March 25, 2022

El Paso County Development Services  
2880 International Circle  
Colorado Springs, CO 80910

SUBJECT: 3511 W. Colorado Avenue, Development Plan

ALTERNATE LANDSCAPE PLAN

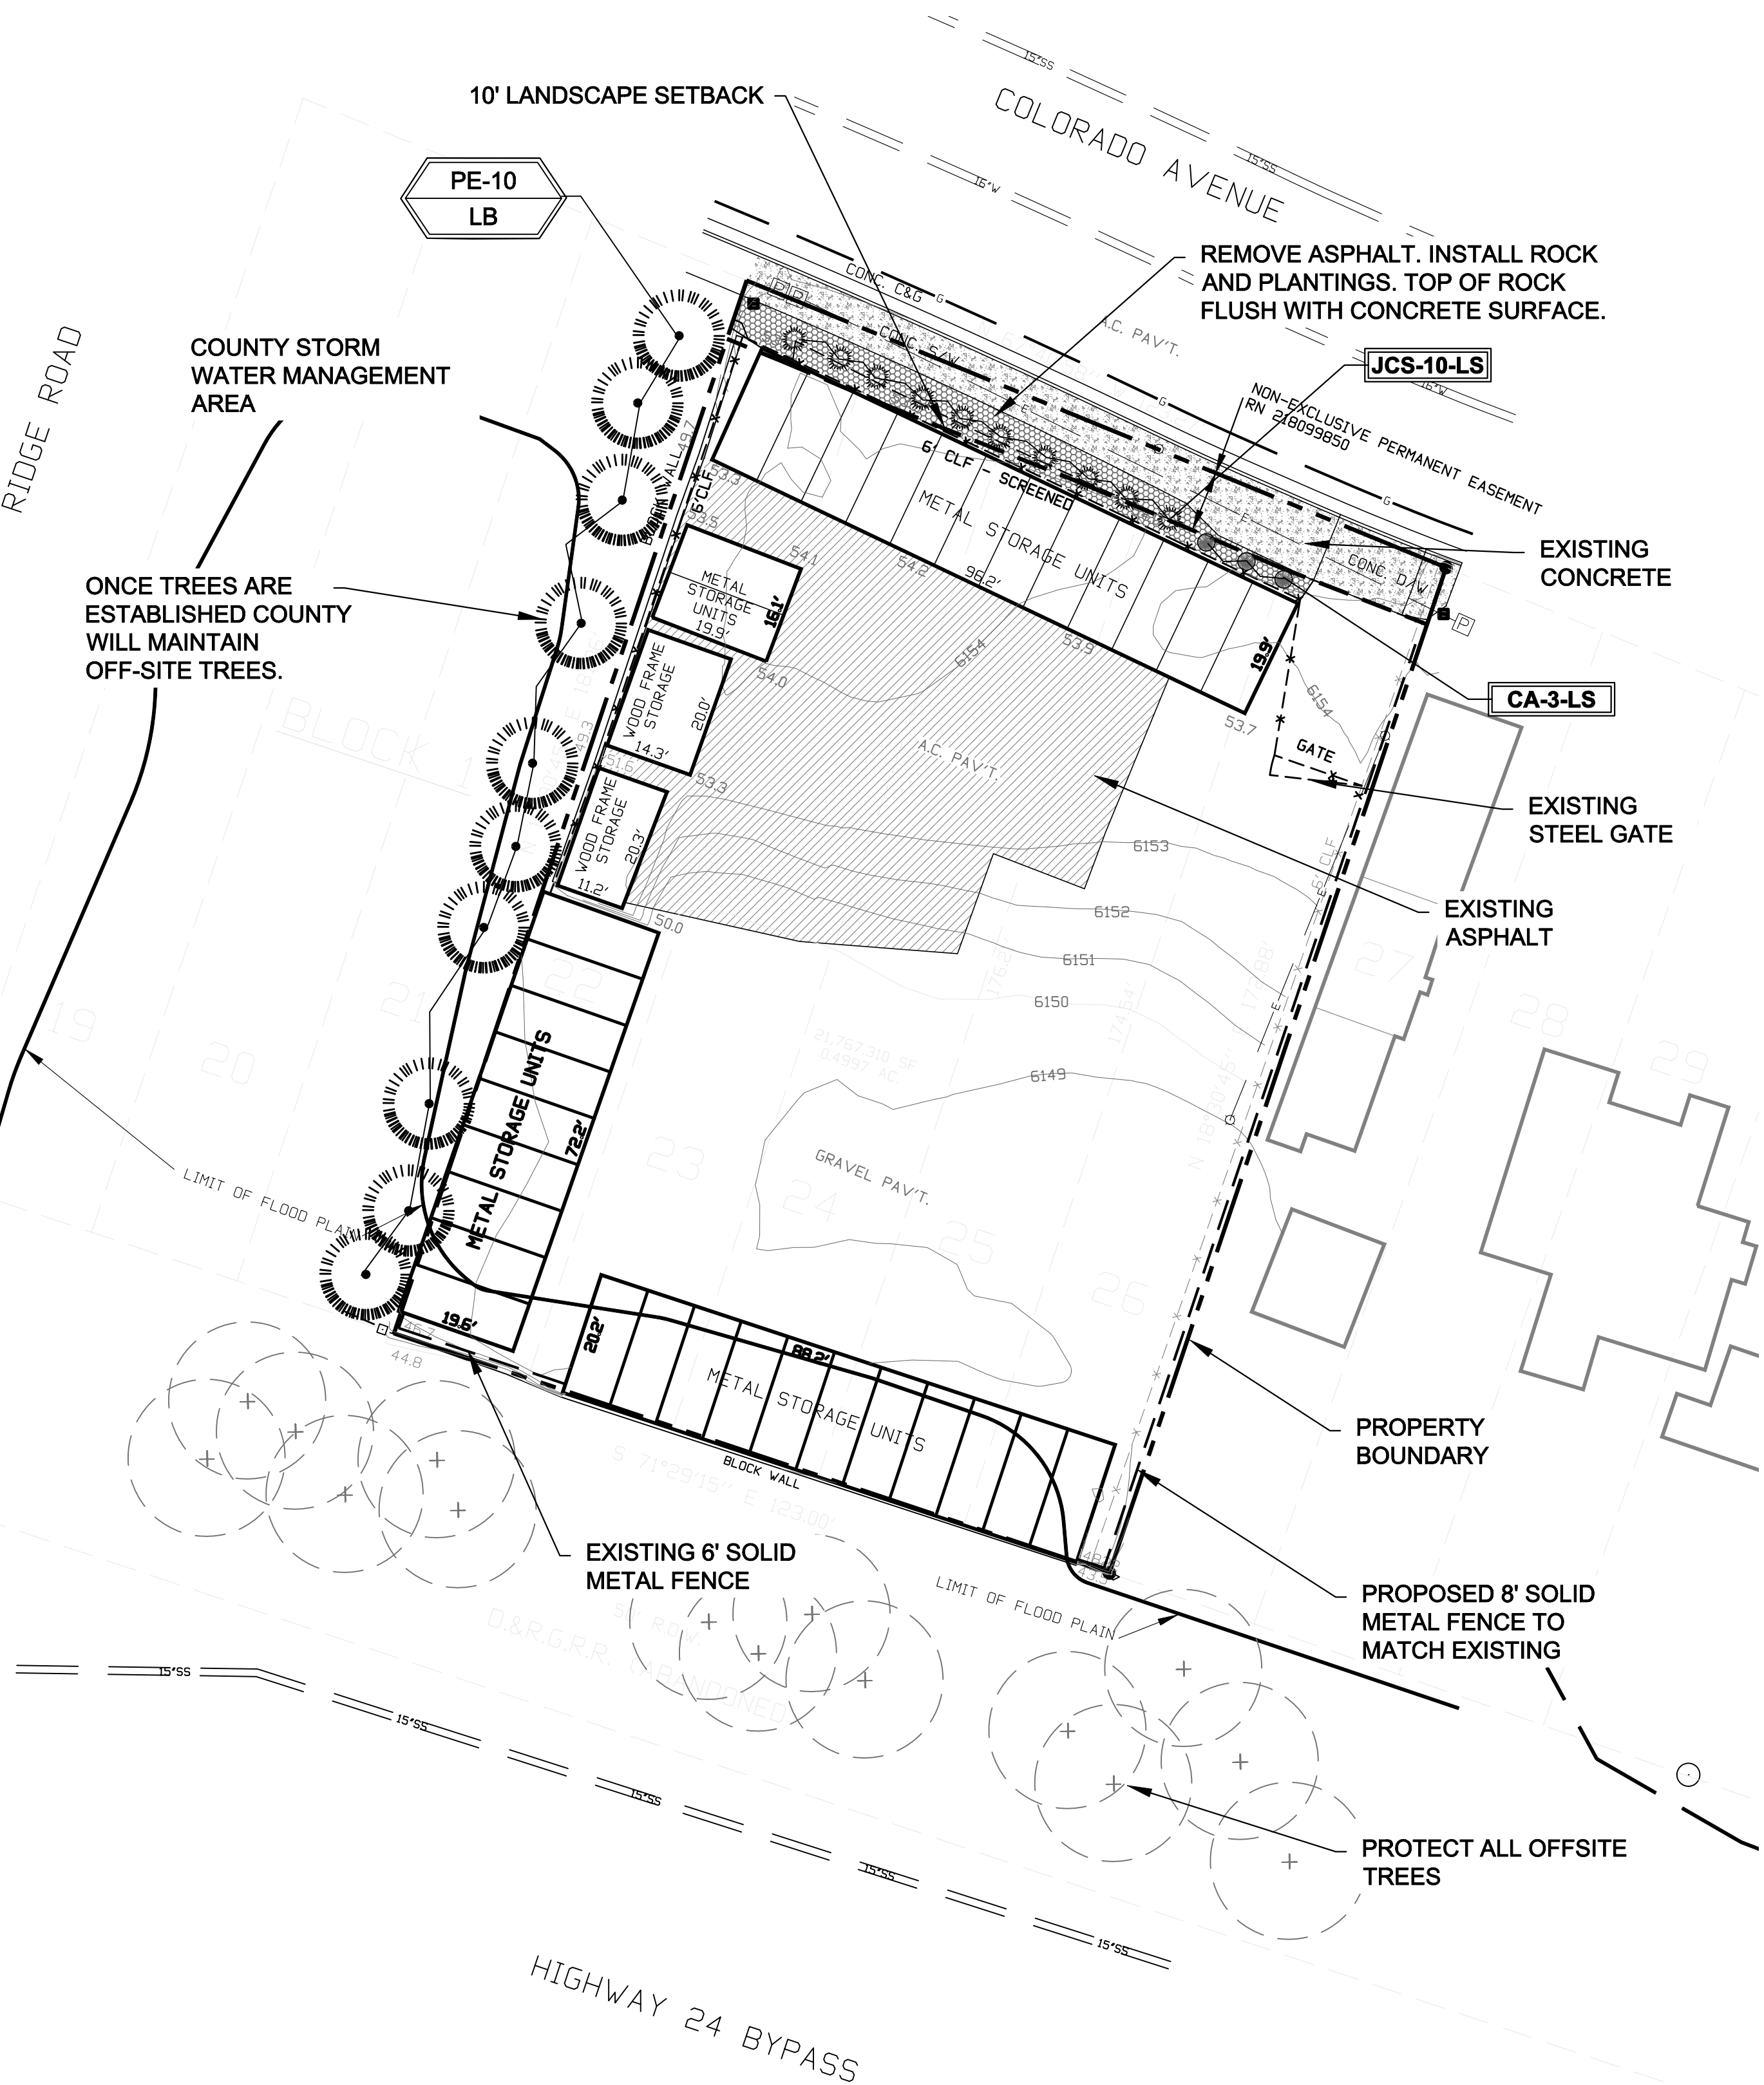
Alternative landscape plan has been requested. Please provide analysis of alternative landscape per LDC Sec. 6.2.2.A.4. See comments on landscape plan for more information.
